CITY OF ALBUQUERQUE

May 20, 2015

**Re: West Mesa High School Classroom Bldg
Erosion Sediment Control Plan
Engineer's Stamp Date 4-16-15 (J10E005)**

**CG-102**

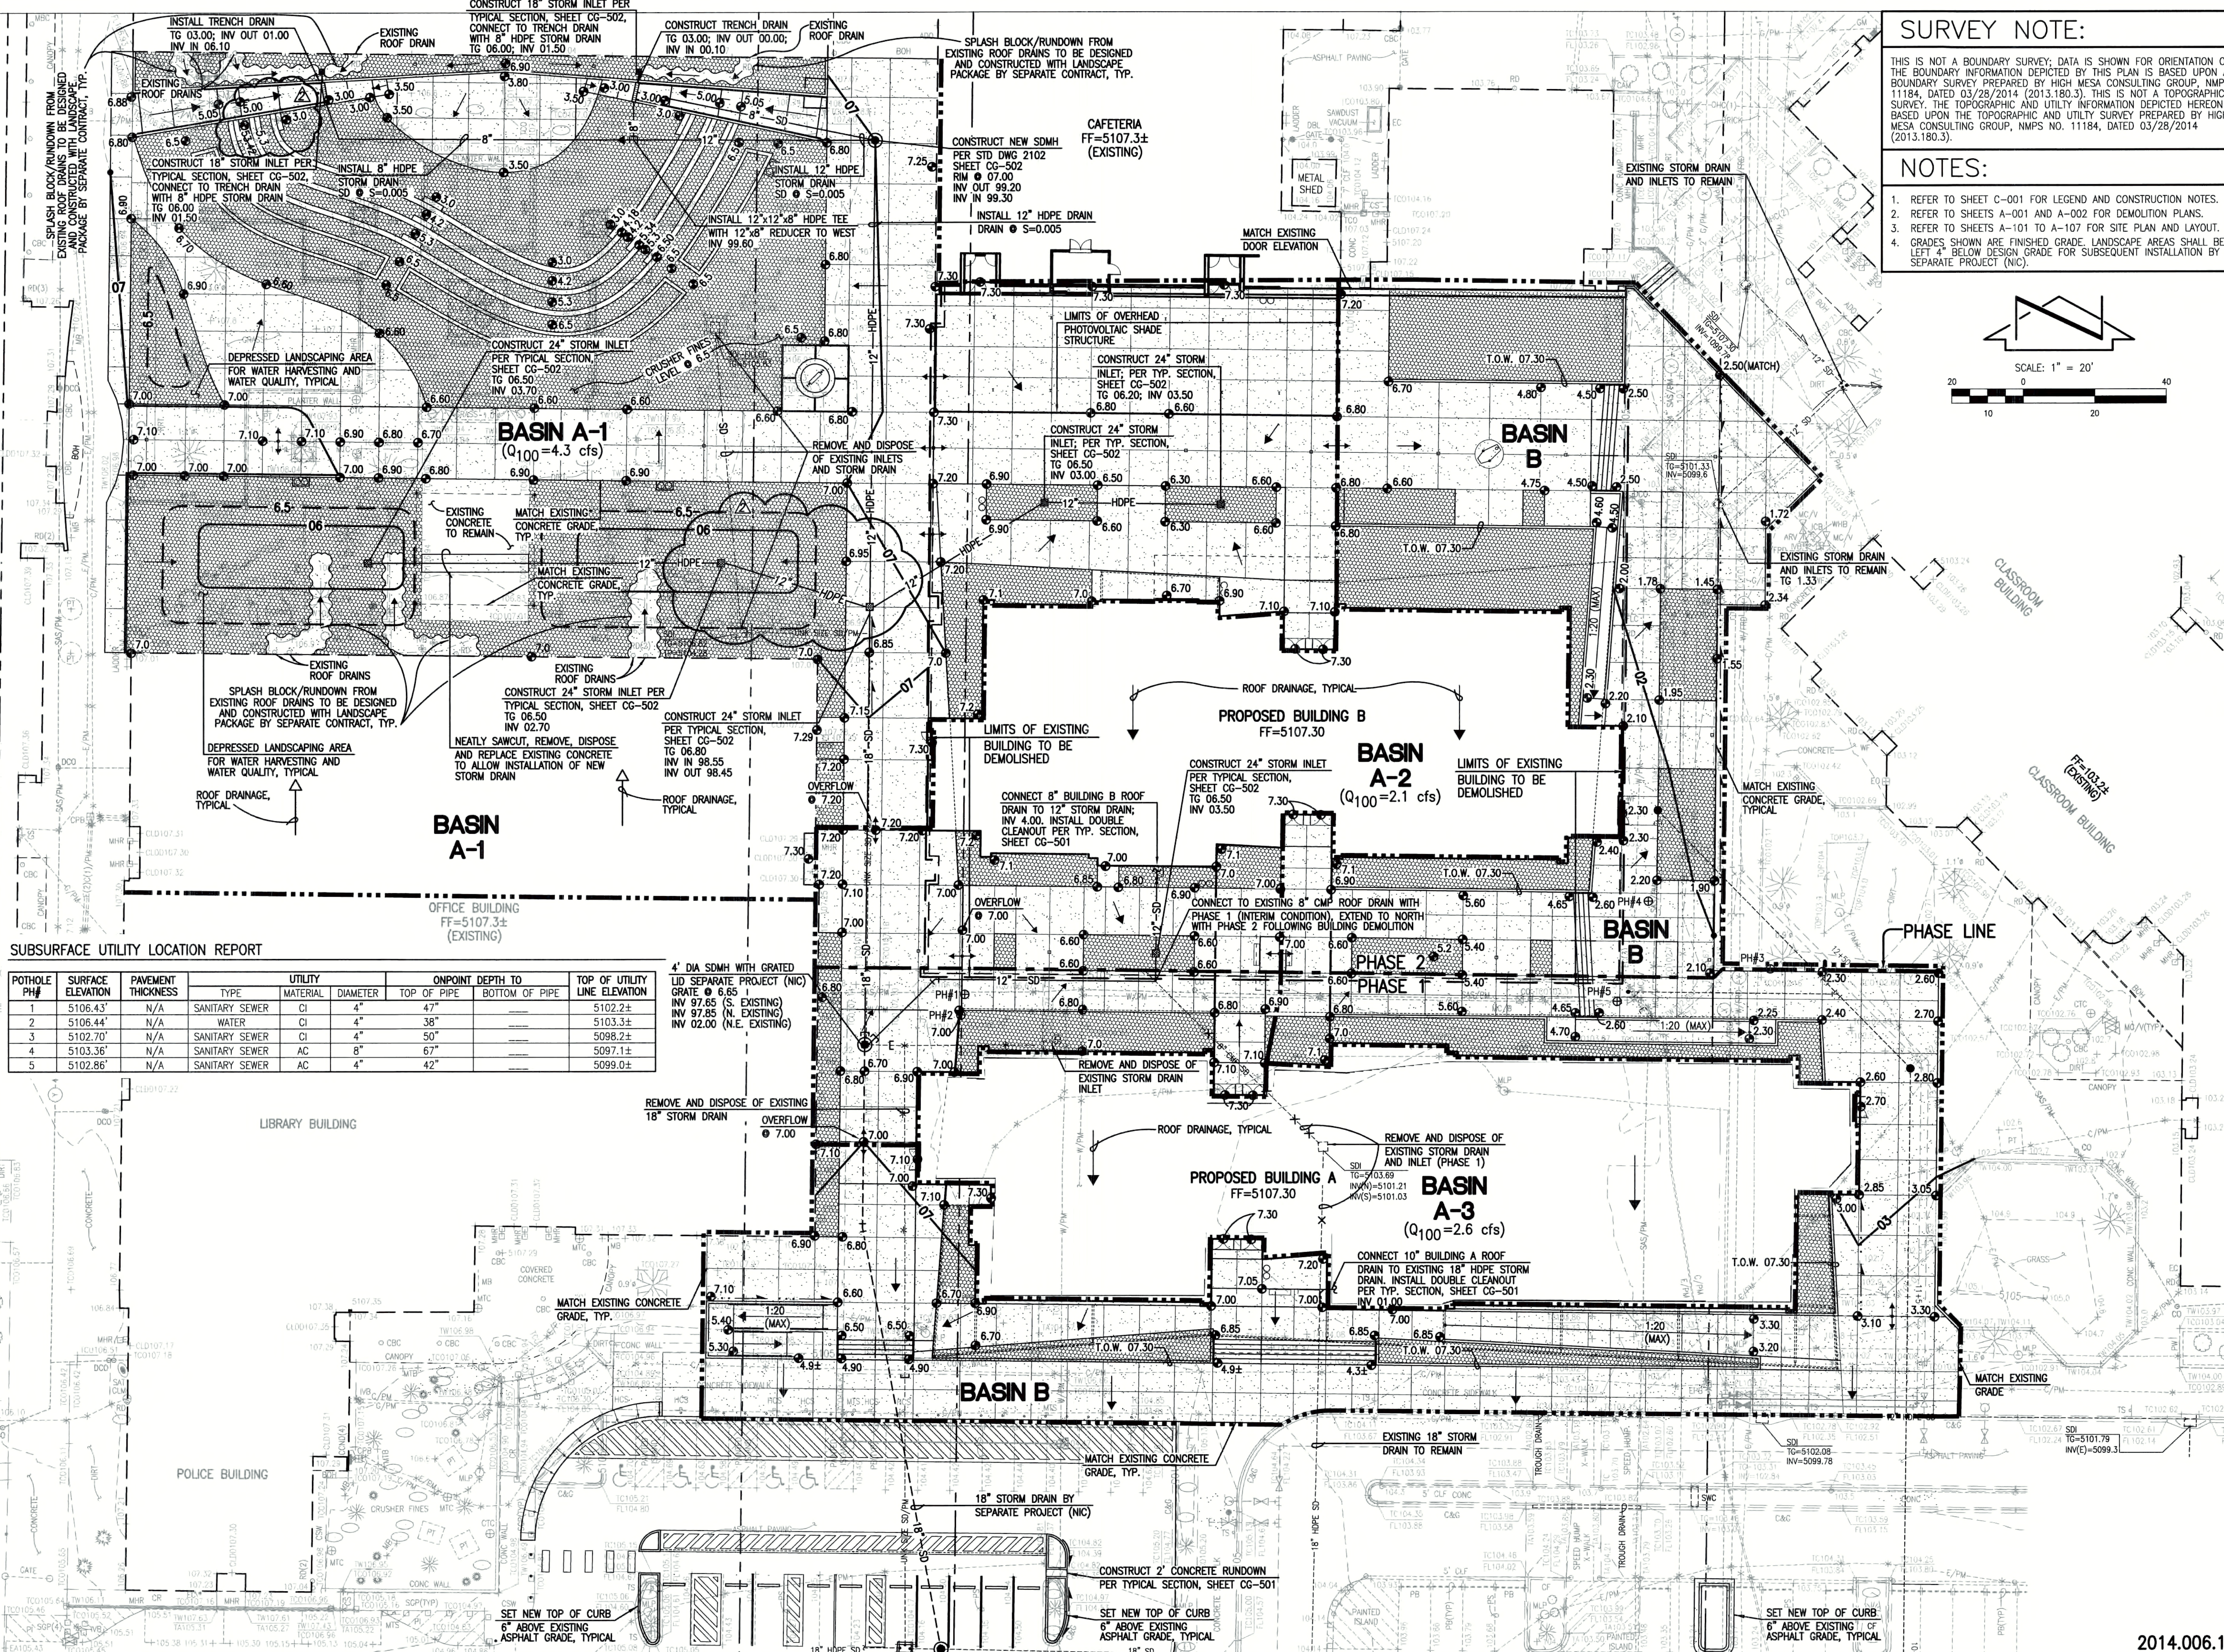
Based upon the information provided in your submittal received 4-16-15 the above referenced plan is acceptable to be included in the SWPPP and for Grading Permit/Building Permit once the grading plan is approved by Hydrology with the condition that inlet protection is provided for the inlet approximately 60 feet northeast of proposed Building B.
